From: Amanda Scholes on behalf of Planning.Responses
Sent: 23 July 2020 08:44
To: Planning Scanning
Subject: FW: Planning Consultation on M/28/20/DOC

Engineers comments;

The level of detail supplied is currently insufficient to enable the discharge of conditions 11, 13 or 14.

Figure 1
Groundwater Level at all Boreholes

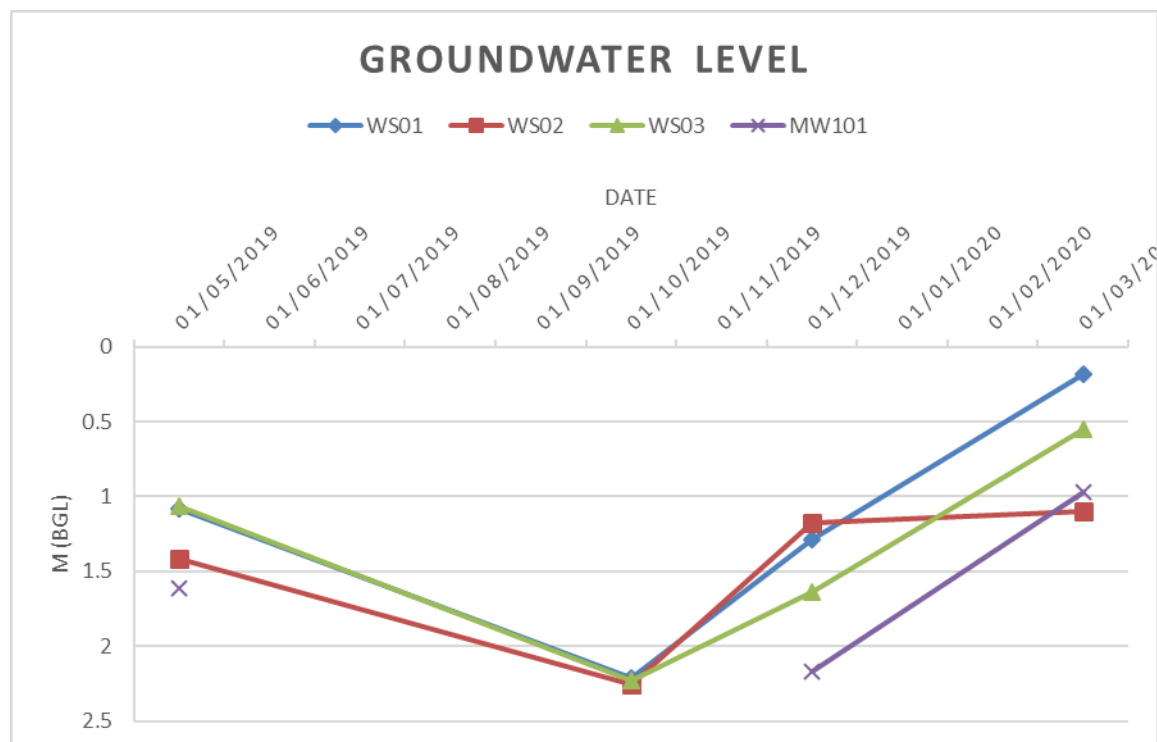
Firstly, we need to be sure that shallow infiltration is not possible, as part of an overall scheme. Please provide a plan showing all the groundwater monitoring point locations and the monitoring results for all, not just WS02. Achieving 1m freeboard between the base of structures and the peak recorded groundwater level is not a requirement in this particular area, so long as the base is above the peak recorded level. This information will dictate as to whether shallow winter infiltration testing will be required.

Figure 4
Route 1 Plan and Section AA'

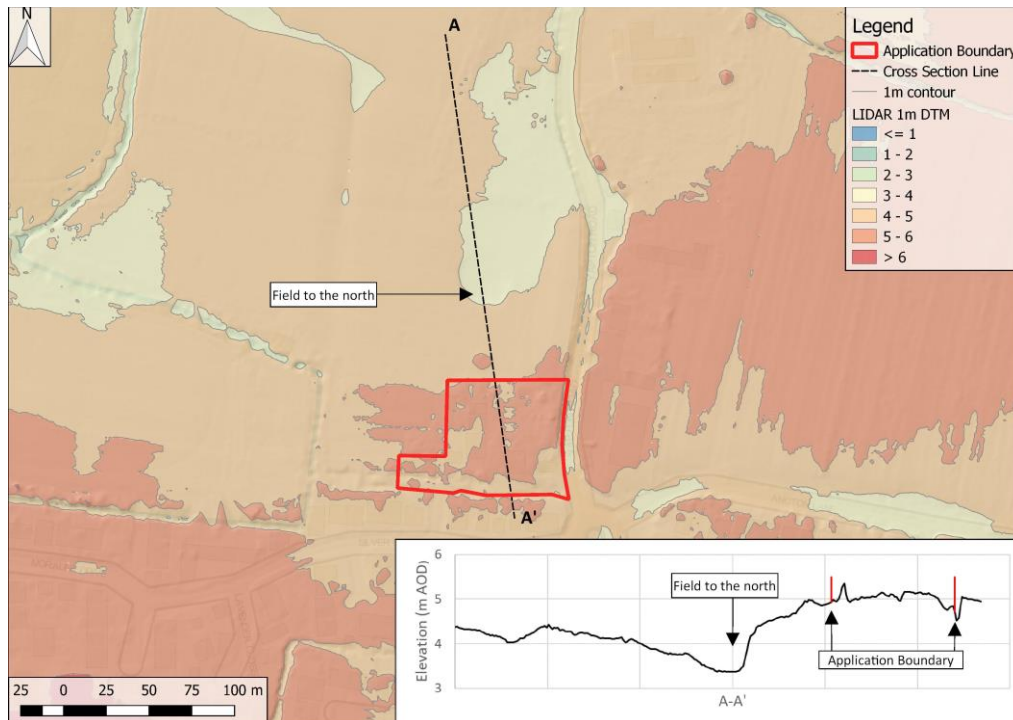
The applicant should also provide topographical evidence to show that no overland/exceedance run off flows from the field to the north will have any detrimental effect on the development/suds.

Site: YAPTON POULTRY FARM
Project: MIDDLETON RESIDENTIAL
Date: 01/07/2020
Drawing: SITE VISIT DISCUSSION
APPENDIX 02

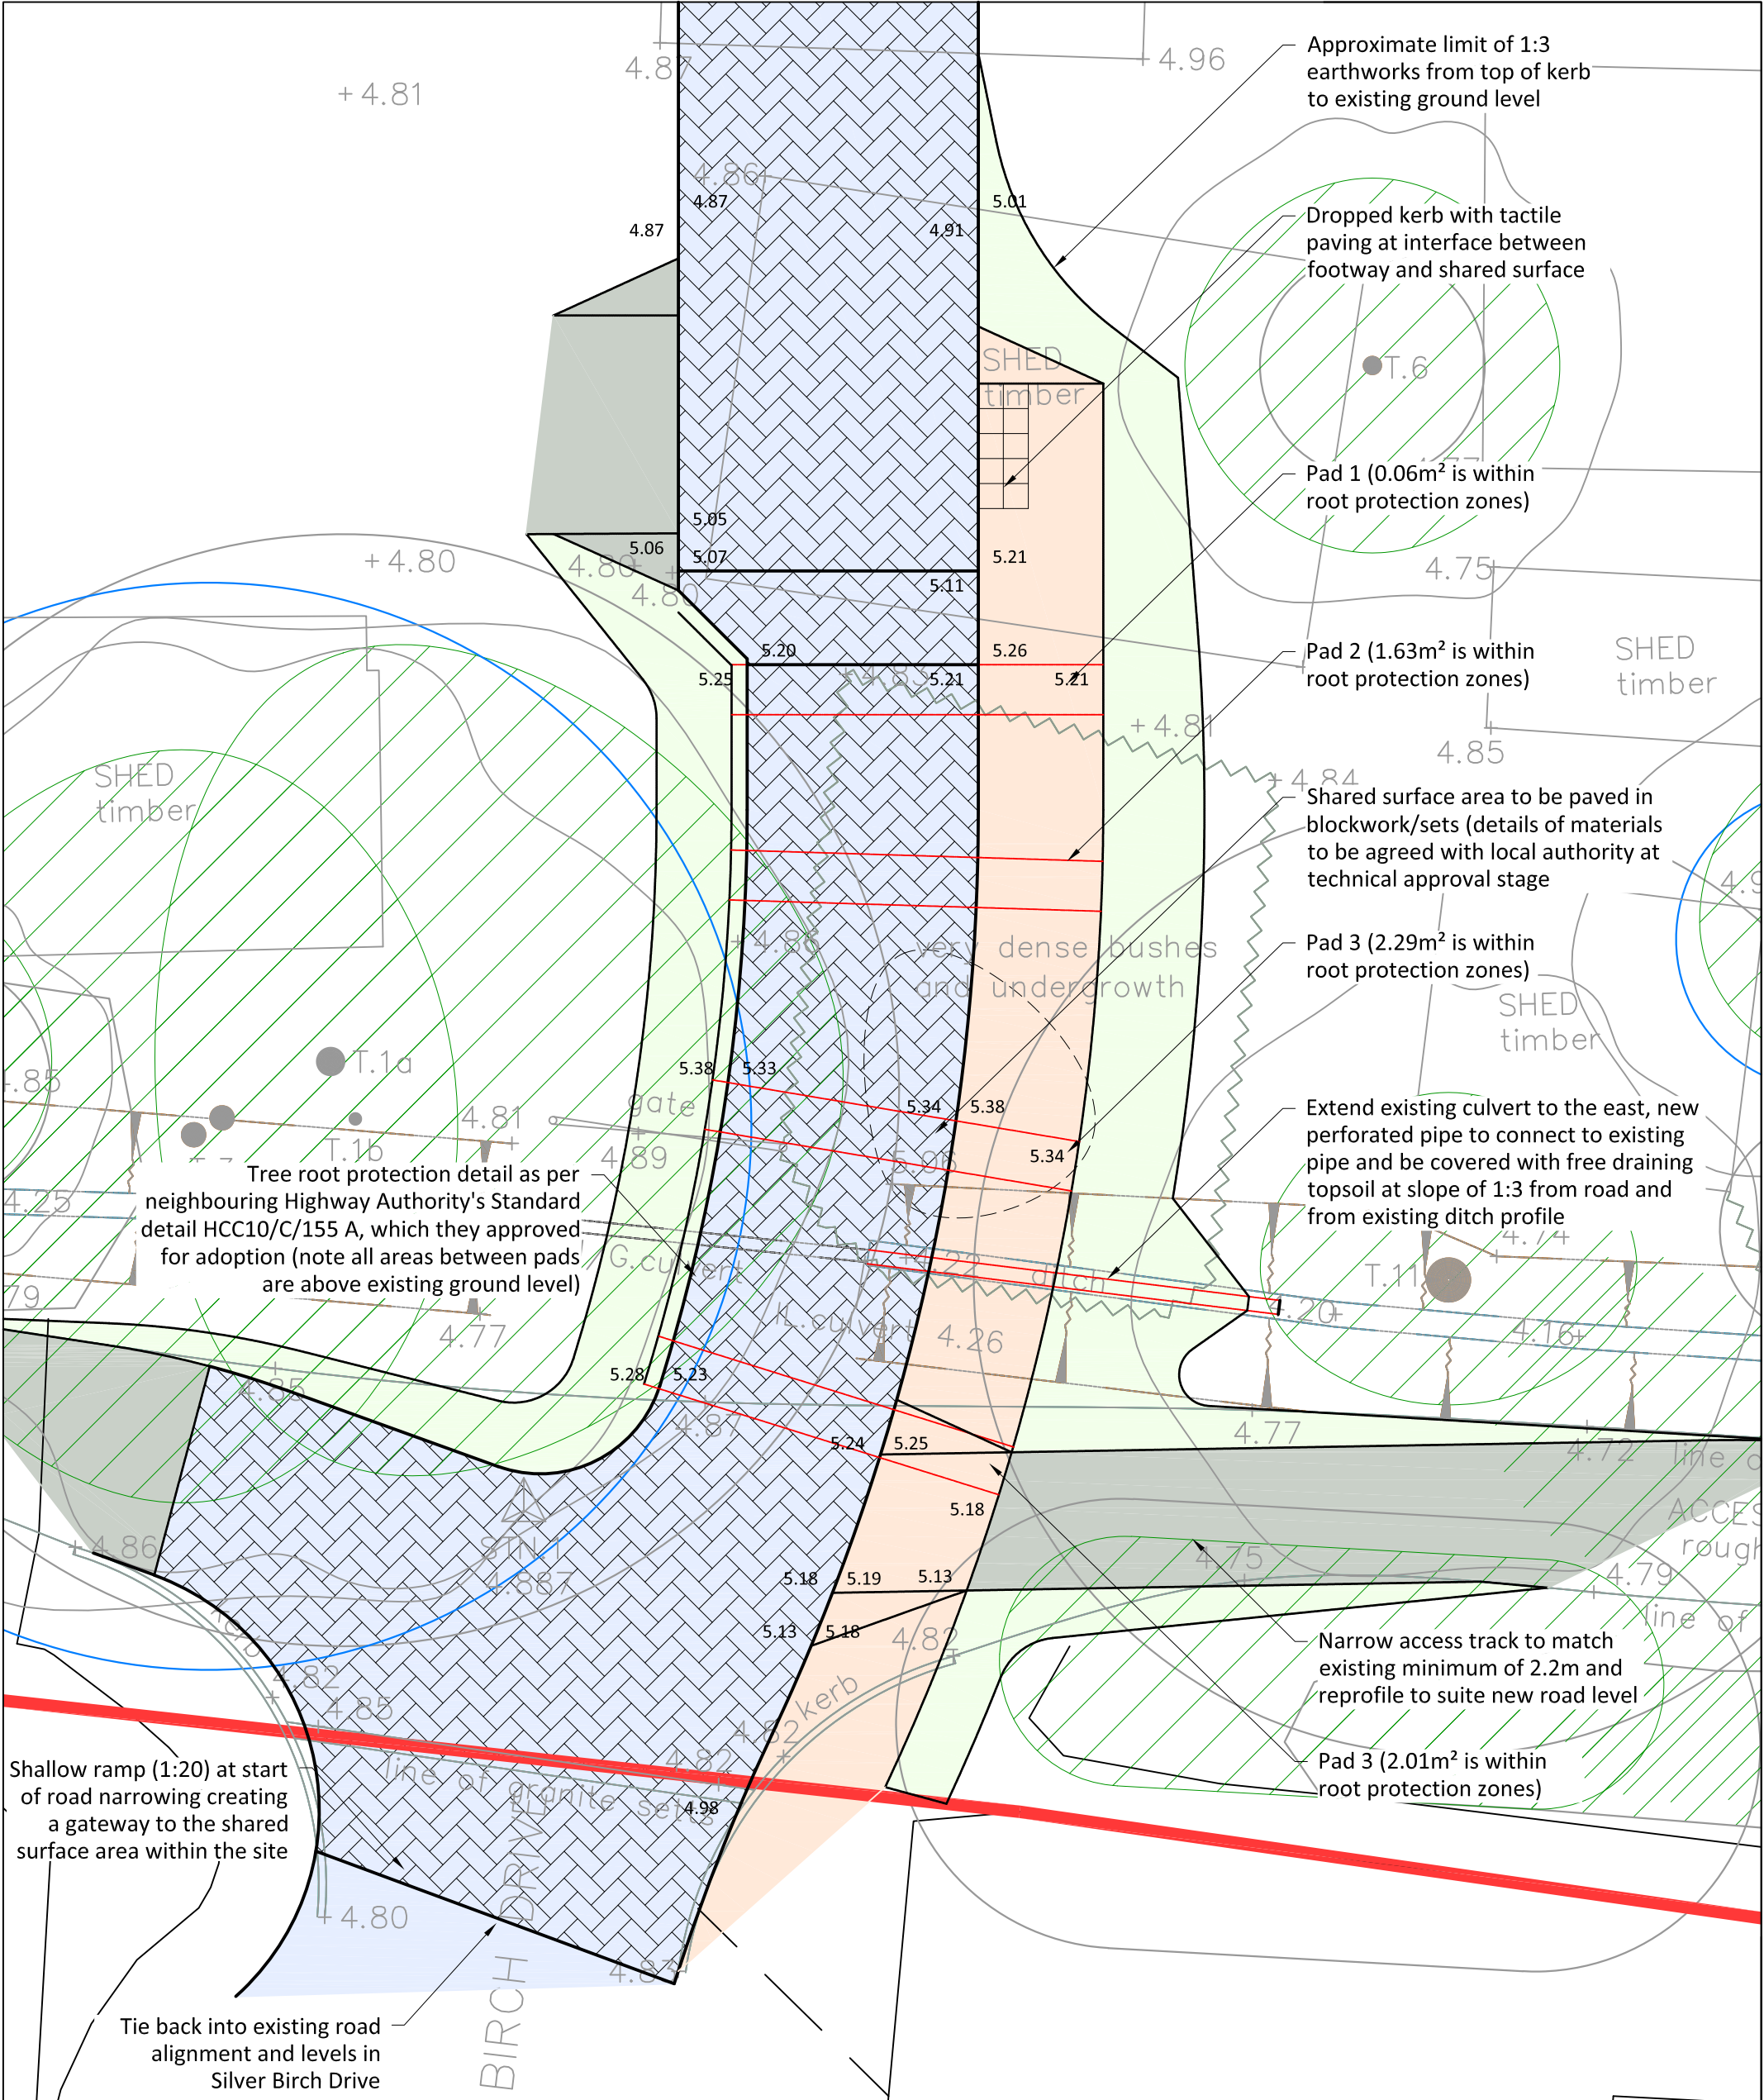
Regarding the ditches on the southern boundary, it is very likely that these will need improvements and I suggest a meeting takes place on site to look at these. Land Drainage Consent will be required for any alterations to them, including culverting and any discharge structures. This will all need to be fully detailed on the drawings.
